ENG-CDR21010-R4-CDs.pdf Markup Summary

VOLLMER NORTH PROFILE (3)
STA 57+00.00 TO 67+50.00

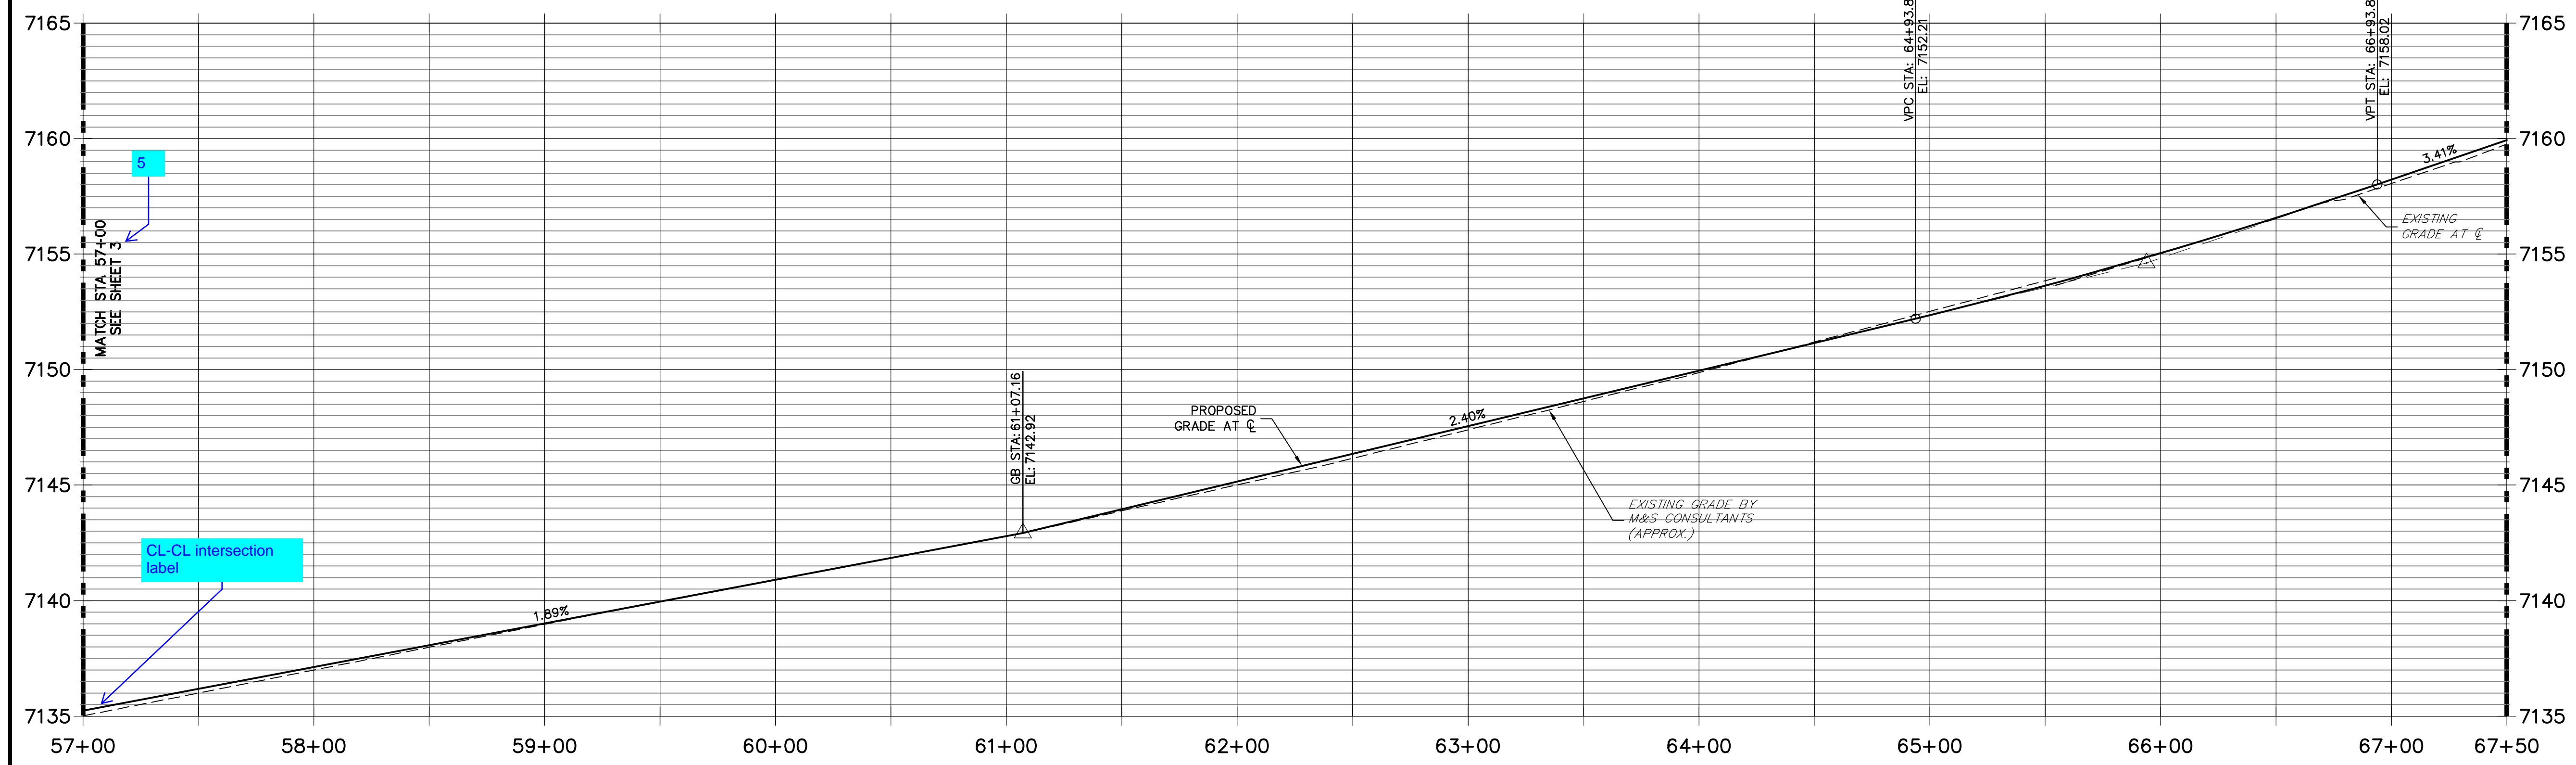
Min K value is 96 for Arterial Road w/45 mph posted speed

VOLLMER ROAD (NORTH)	SIGNAGE & STRIPING	BY	DATE
		NO.	REVISION
H-SCALE	1"=40'	V-SCALE	N/A
DATE	5/9/22	DESIGNED BY	CWC
DRAWN BY	SWW	CHECKED BY	
SHEET 9 OF 16		JOB NO. 25188.00

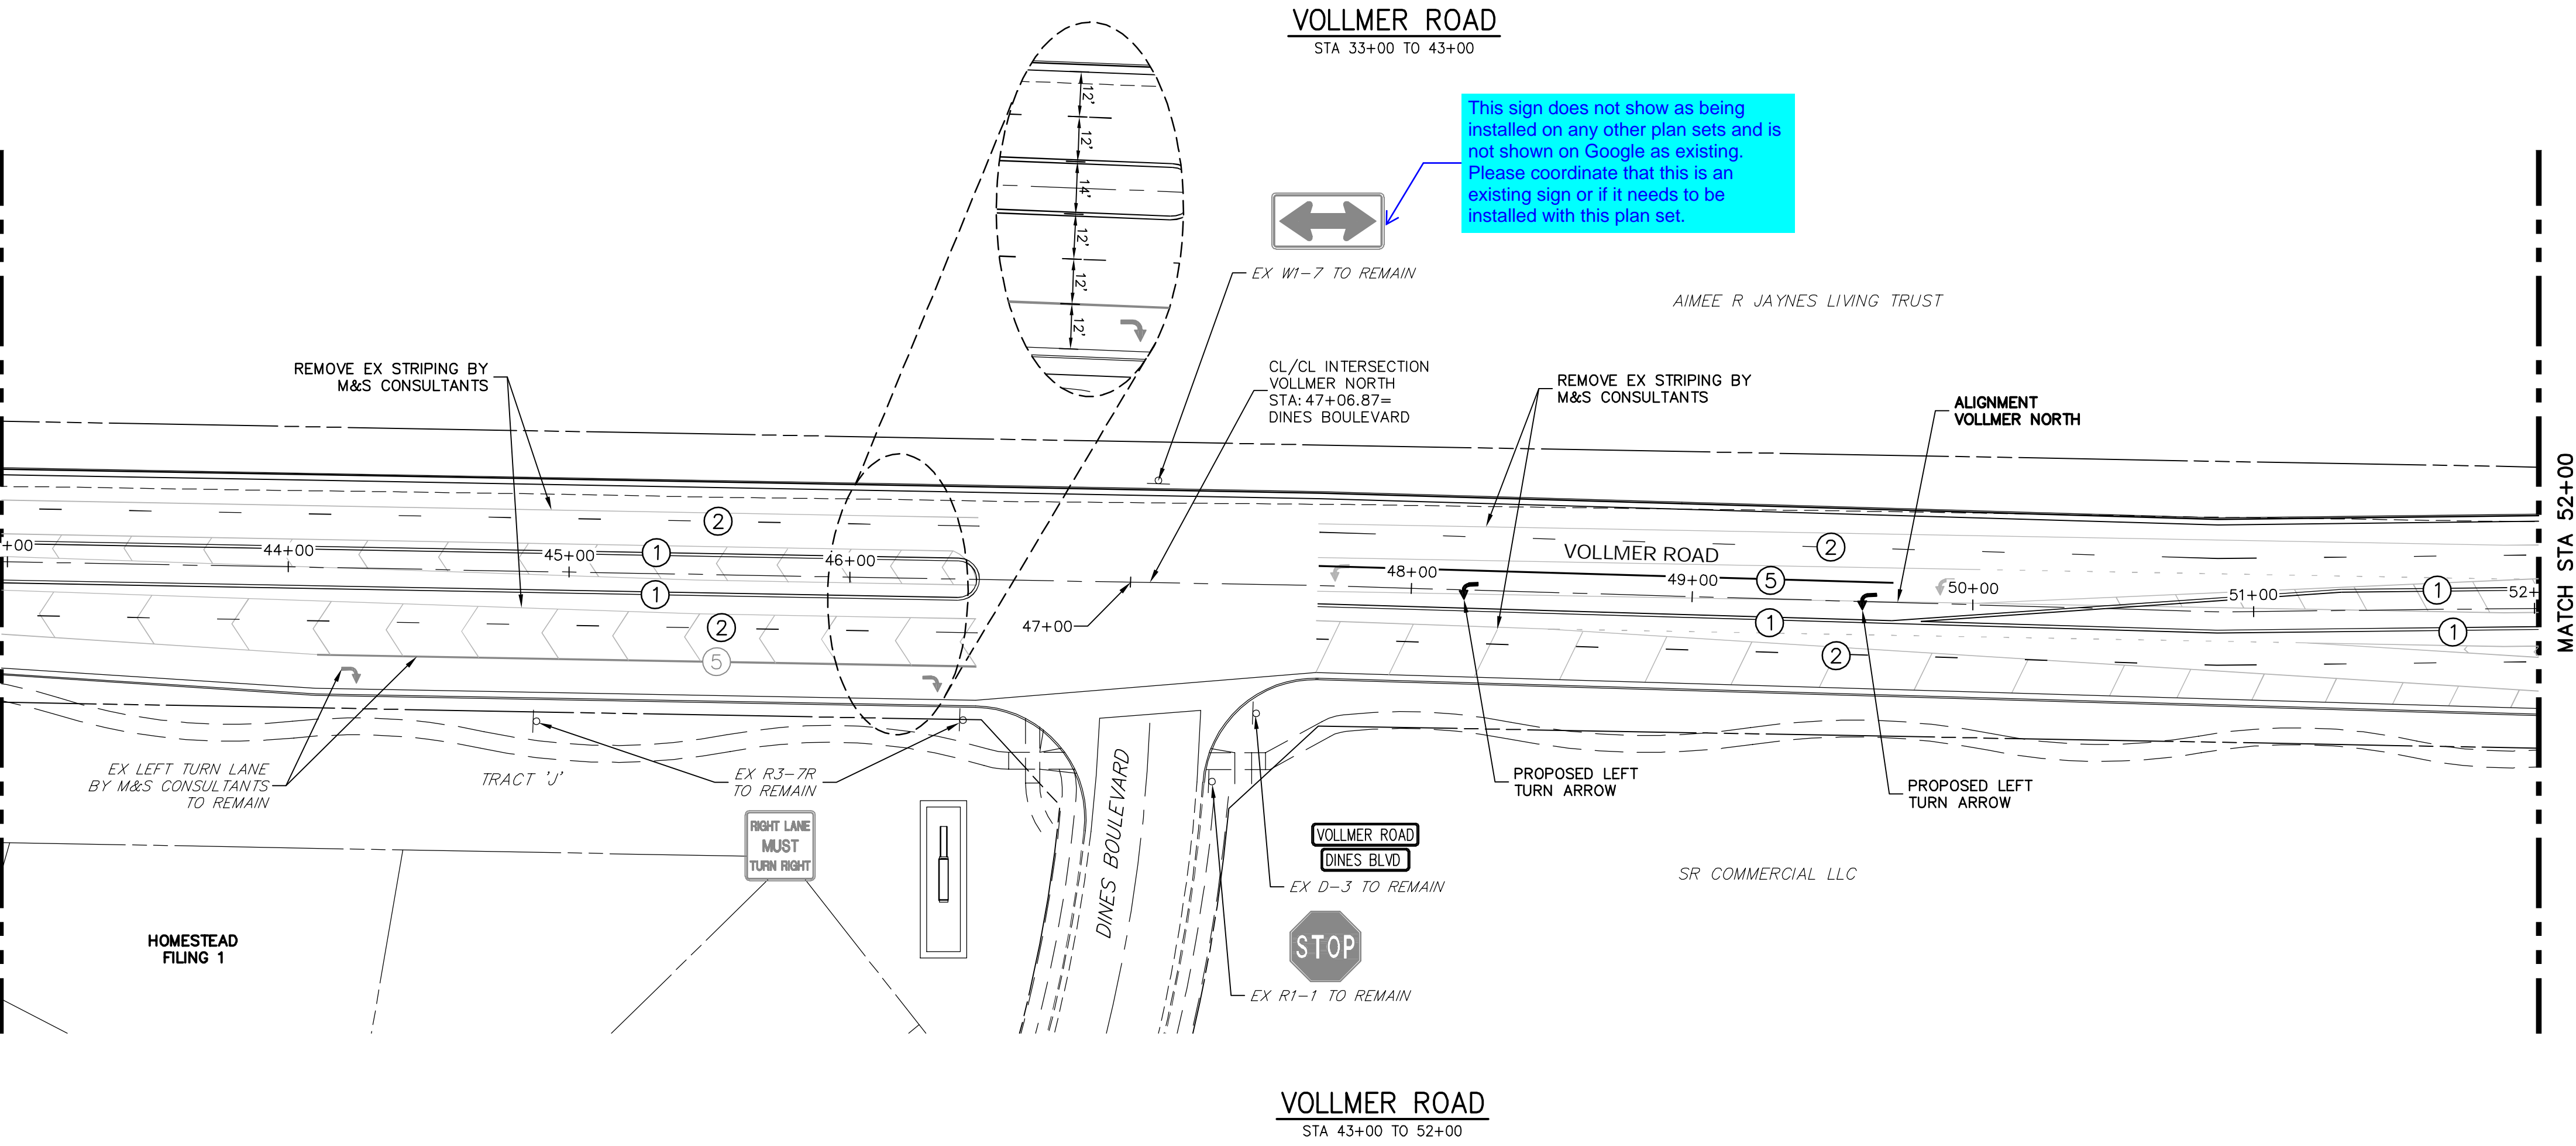
45 mph sign
